Your ref:	Lupus St	Please reply to:	Mr Anthony Perera
Our ref:	21/06523/LBC	Tel No:	07866034072
		Fee Queries:	0207 641 6500;
		Email:	planningreception@westminster.gov.uk;
Roger Crimlis AUSB Ltd 60 farleigh road London N16 7TQ United Kingdom		Incomplete Applications Development Planning City of Westminster PO Box 732 Redhill, RH1 9FL	
		18 October 2021

Address: Third Floor And Fourth Floor Maisonette, 8 Lupus Street, London, SW1V 3DY,

Proposal: Addition of a acoustic insulation to the third floor flooring, internal alterations to create WC, upgrades to the existing boiler and the addition of two vent outlets on the front elevation at third floor level.

Existing and proposed front elevation

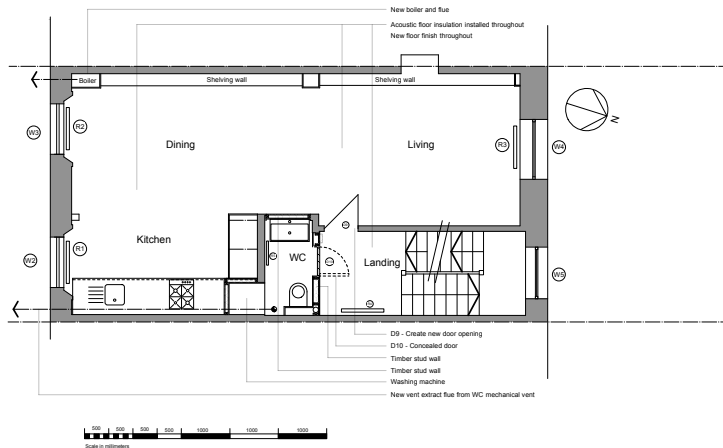
-Details of vents to be installed to front facade (please note that it would be expected that any grills of vents are traditional cast iron air bricks to match existing)
